Re: Planning Application 19/1031 and 1032

Address: Plots 1 and 2, 8 Hammond Drive Read BB12 7RE

Description: Proposed two-story dwelling house with integral garage, parking and drive access.

Plot 1
Site Layout & Sections

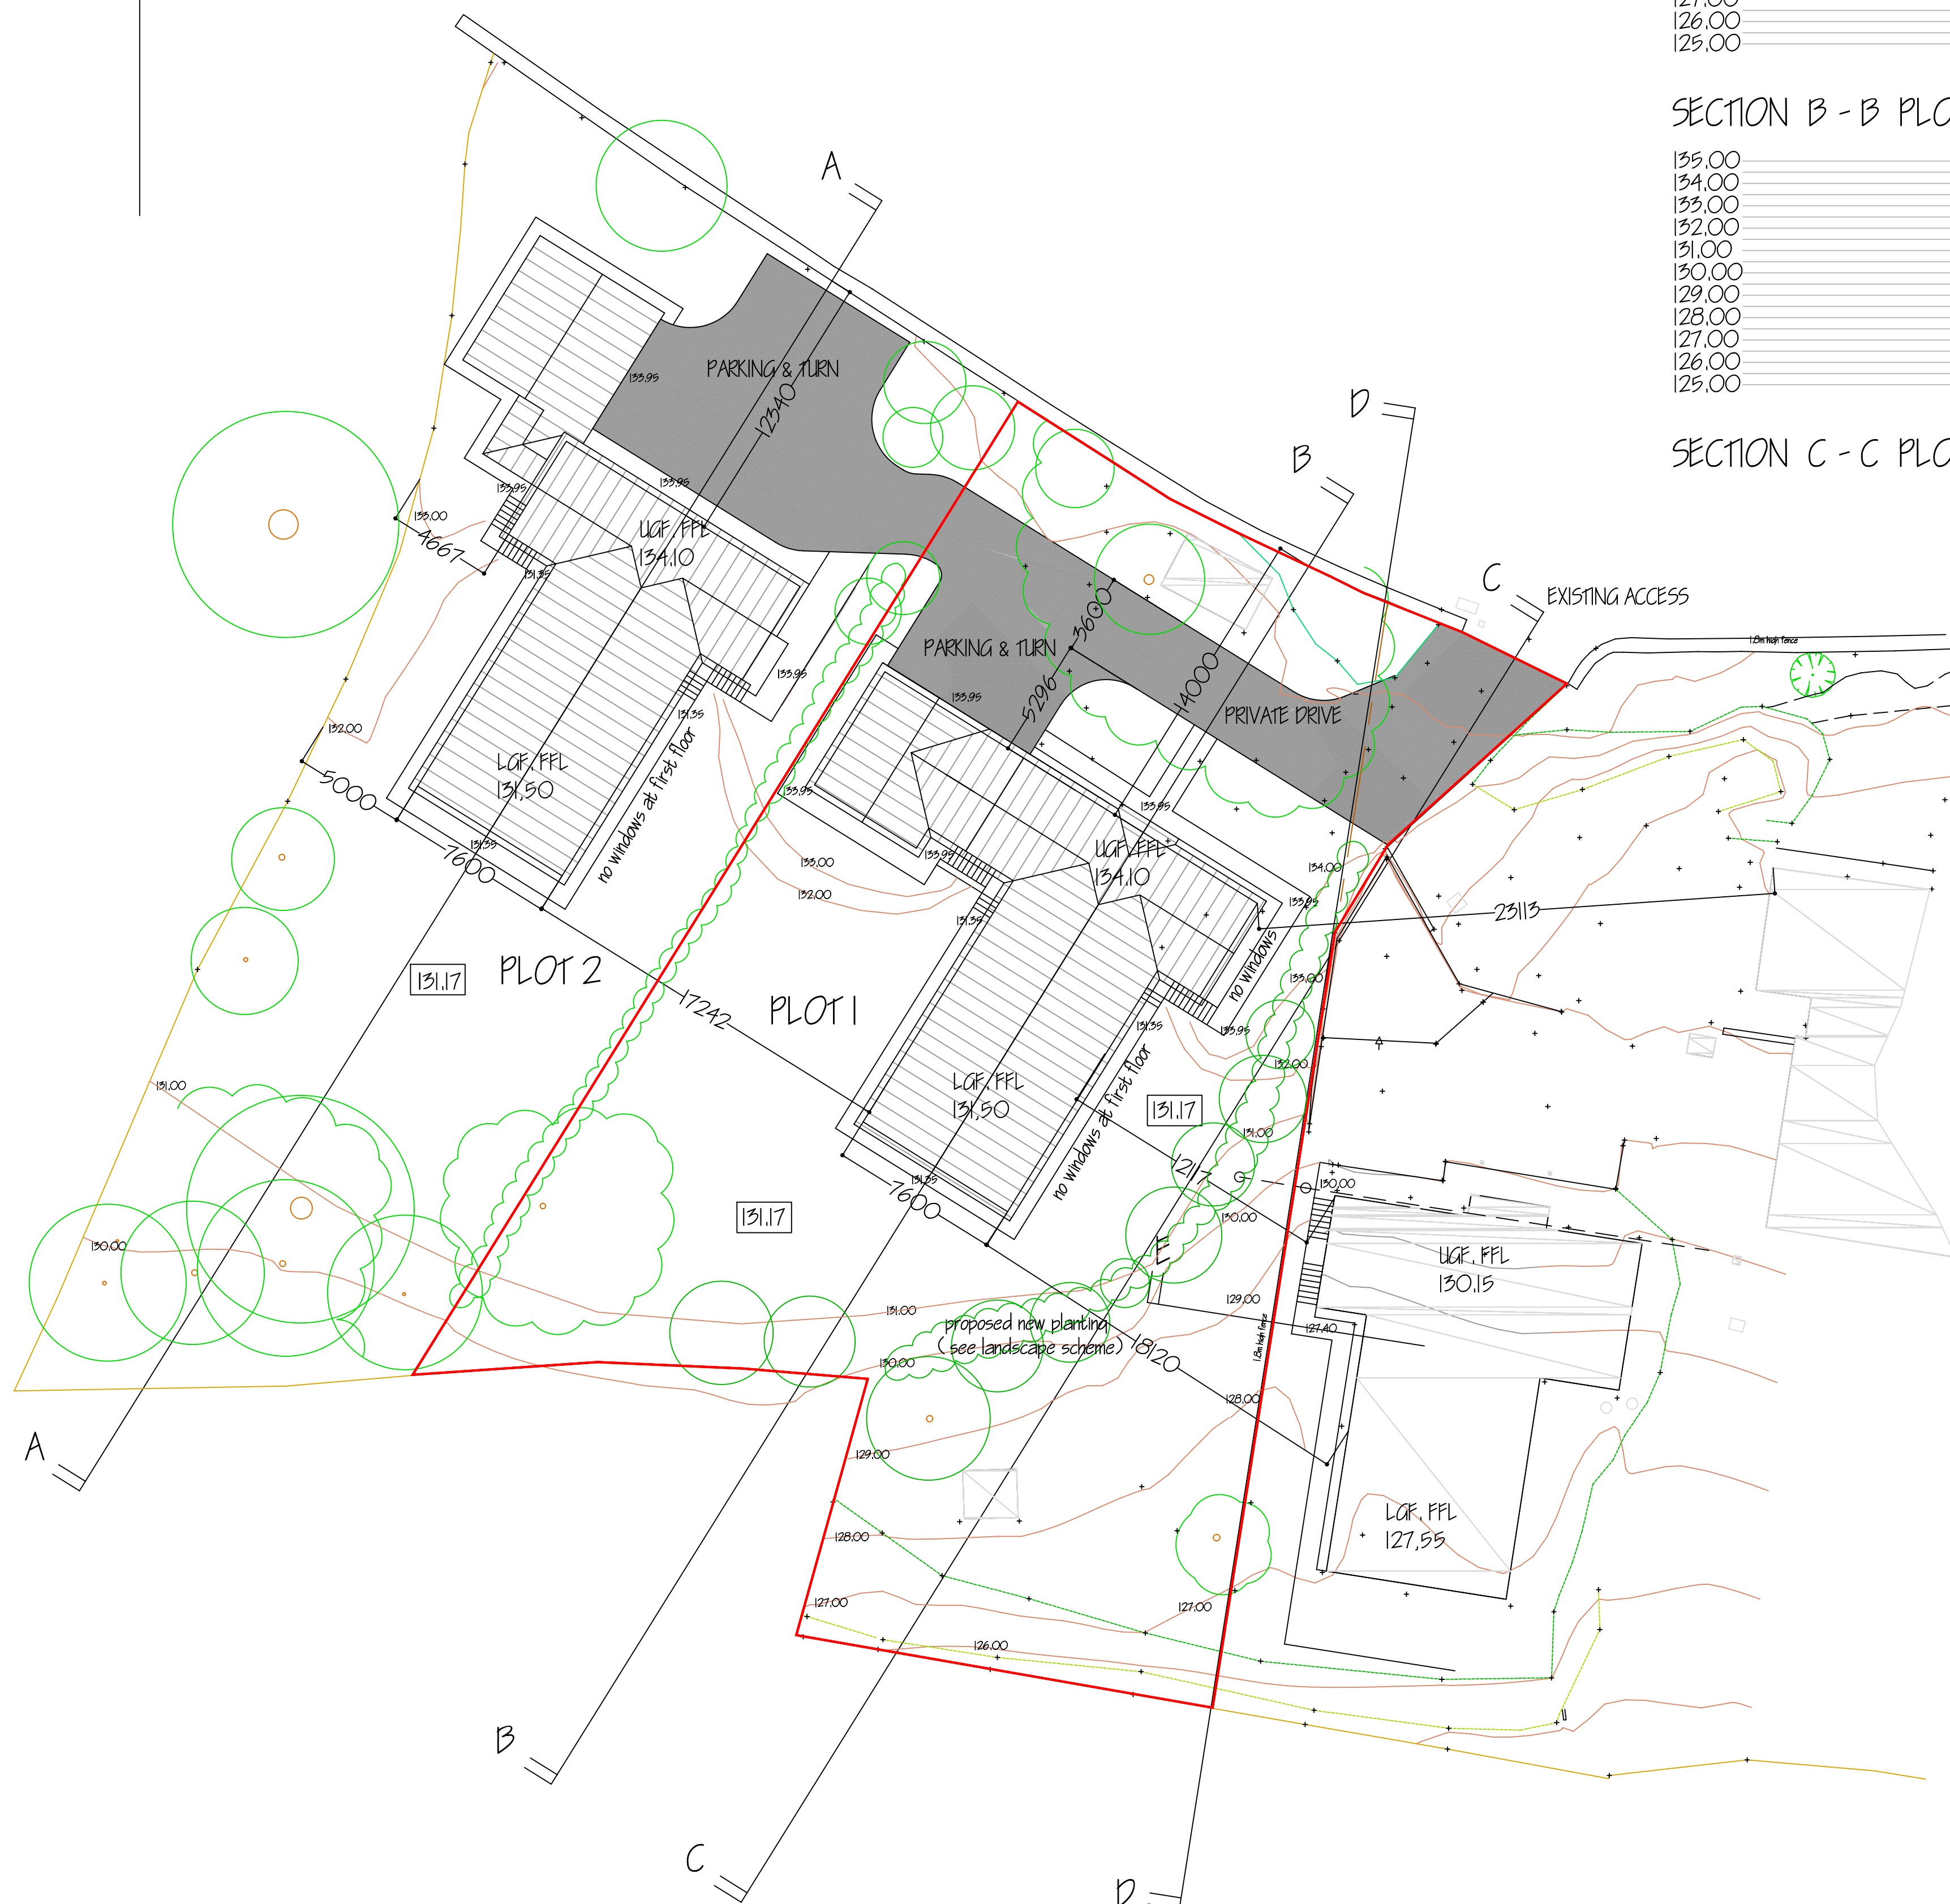
It is apparent that this access is now to support 3 dwellings and it is felt that the existing gap is too narrow to allow two vehicles to pass as they enter and exit the site.

In order to support the application we would look for a widened access and a plan with a swept path analysis to allow for 2 family cars, such as a Ford Mondeo to pass in the widened access.

1. Before the access is used for vehicular purposes, that part of the access extending from the highway boundary for a minimum distance of 5m into the site shall be appropriately paved in tarmacadam, concrete, block pavements, or other approved materials. **Reasons:** To prevent loose surface material from being carried on to the public highway thus causing a potential source of danger to other road users.
